CITY OF ALBUQUERQUE

Re: Juan Tabo Hills Unit 3A Grading and Drainage Plan
Engineer's Stamp dated 4-10-12 (M22/D015)

Based upon the information provided in your submittal received 4-10-12, the above referenced plan cannot be approved for Preliminary Plat action by the DRB until the following comments are addressed:

JUAN TABO HILLS UNIT - 3A
GRADING & DRAINAGE PLAN

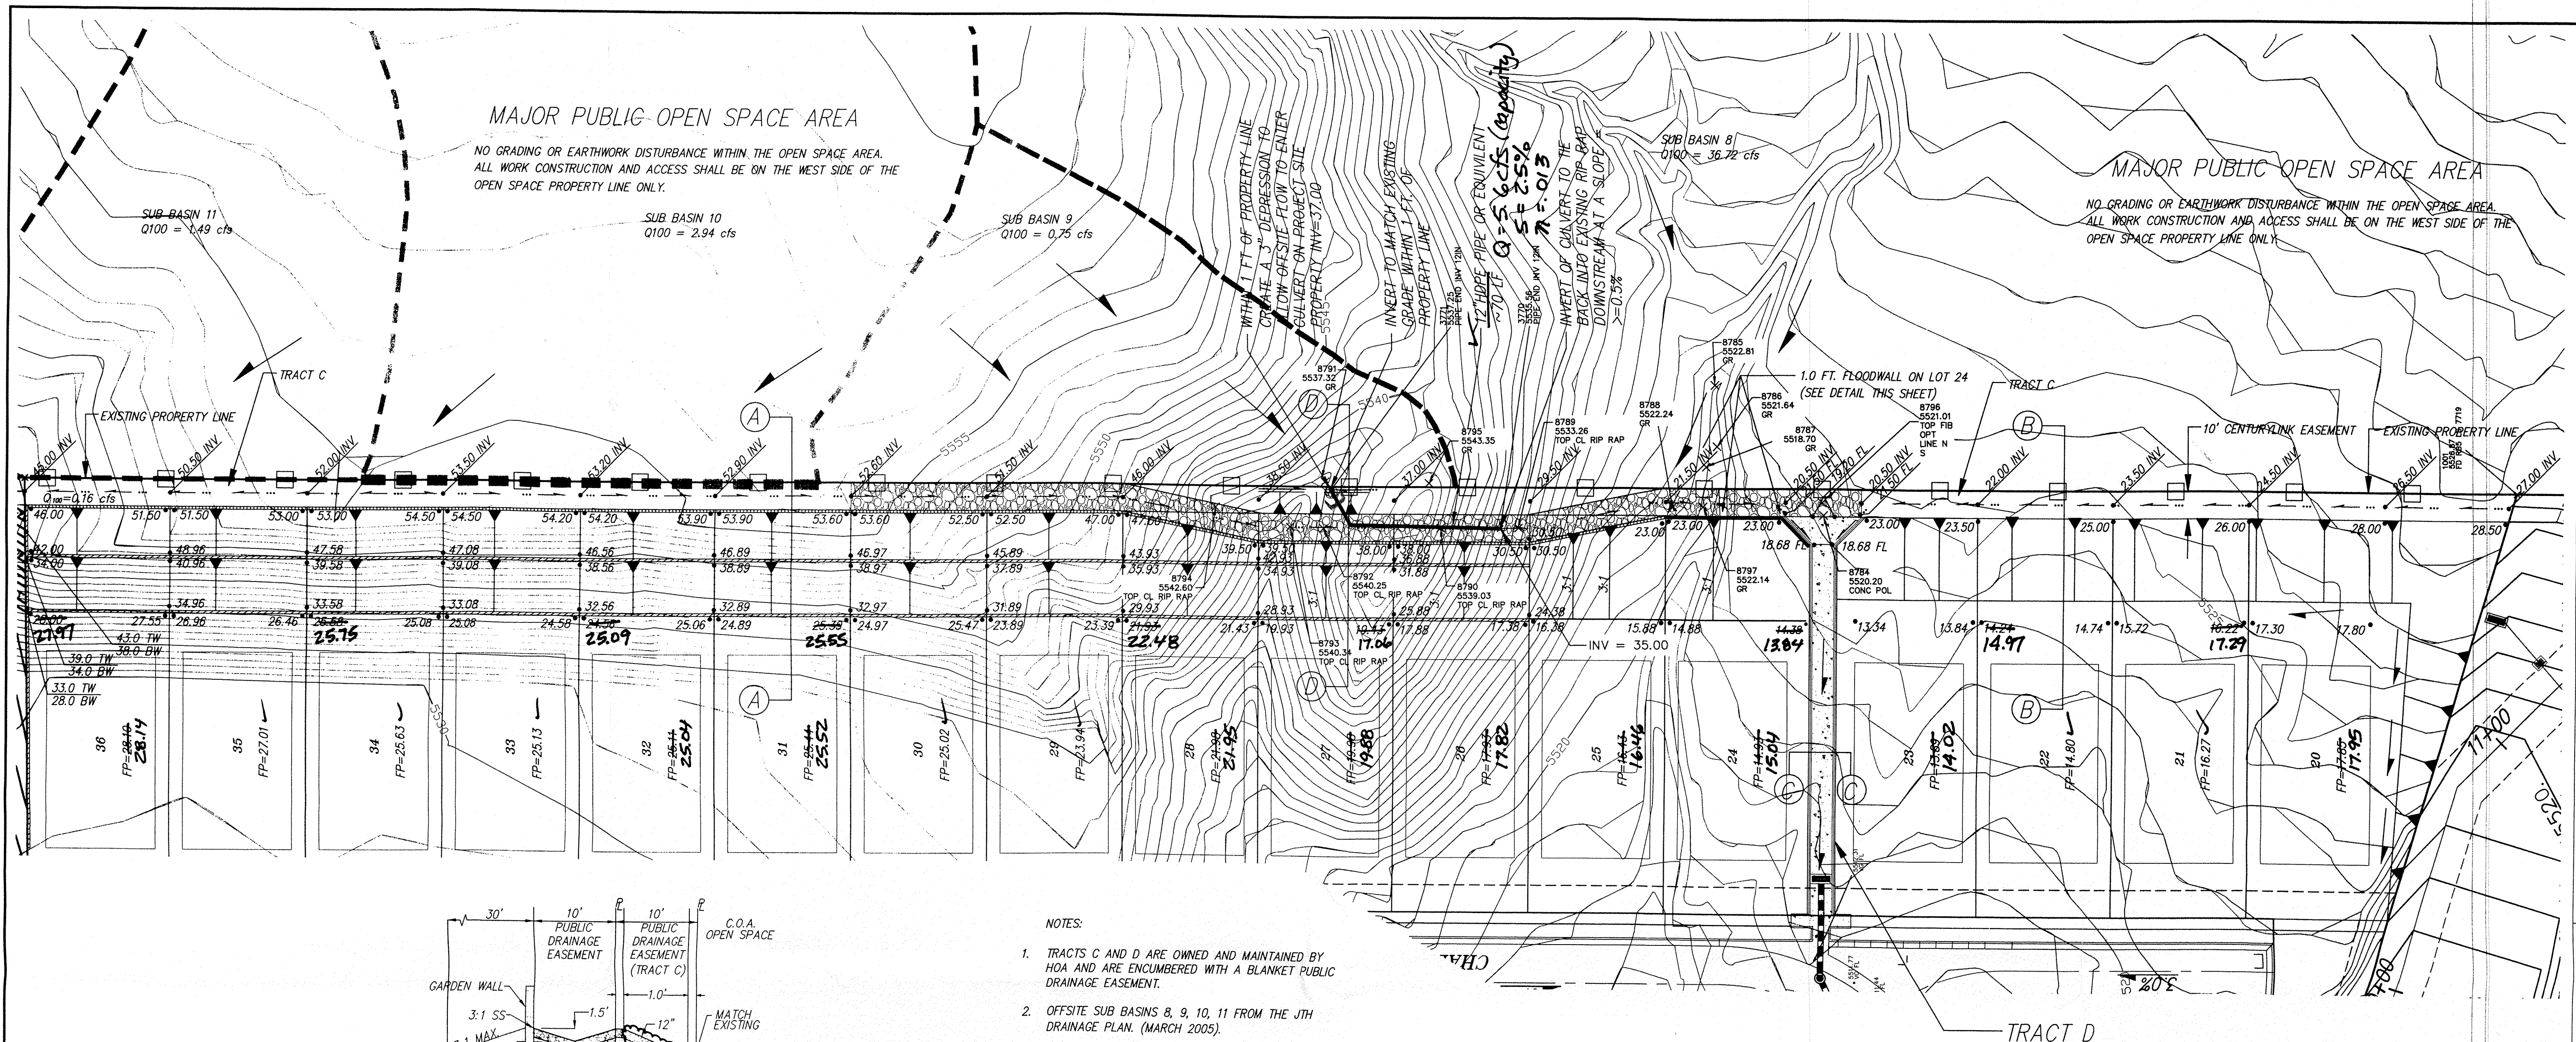
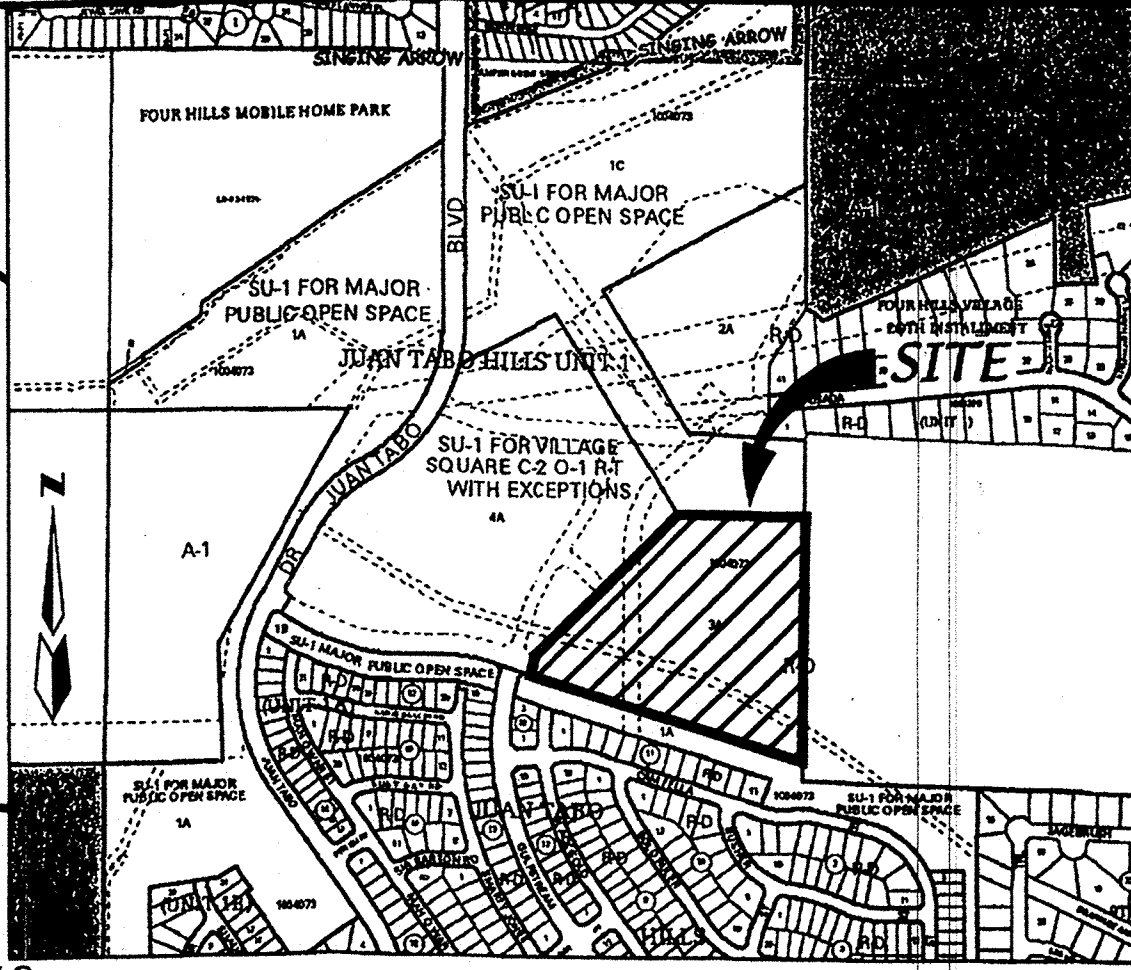
- There is an approximately 15 to 20 foot cut in Tract 1-C, the Open Space tract, just north of Lots 36 to 38. The grading plan does not show any proposed grades in this area. Which grading plan approved grading in this area?

- Three separate grading plans (3A, 3B, and Volterra) proposed grades in Tract 1-C, which does not provide a clear picture of the proposed grading in this tract. Provide a grading plan that shows existing and proposed grades in Tract 1-C that combines previously approved grades from the grading plans from Juan Tabo Hills 3A, 3B and Volterra. This plan should show some overlap into the subdivisions so that it is clear how grades tie together.

- Additional comments may be provided after review of the above mentioned grading plan.
- Proposed grades southeast of the Gulf Stream cul-de-sac may produce an unstable slope. Provide proposed spot elevations near the Tract 1-C property line in this area. Grades should also be provided west of Gulf Stream Dr.
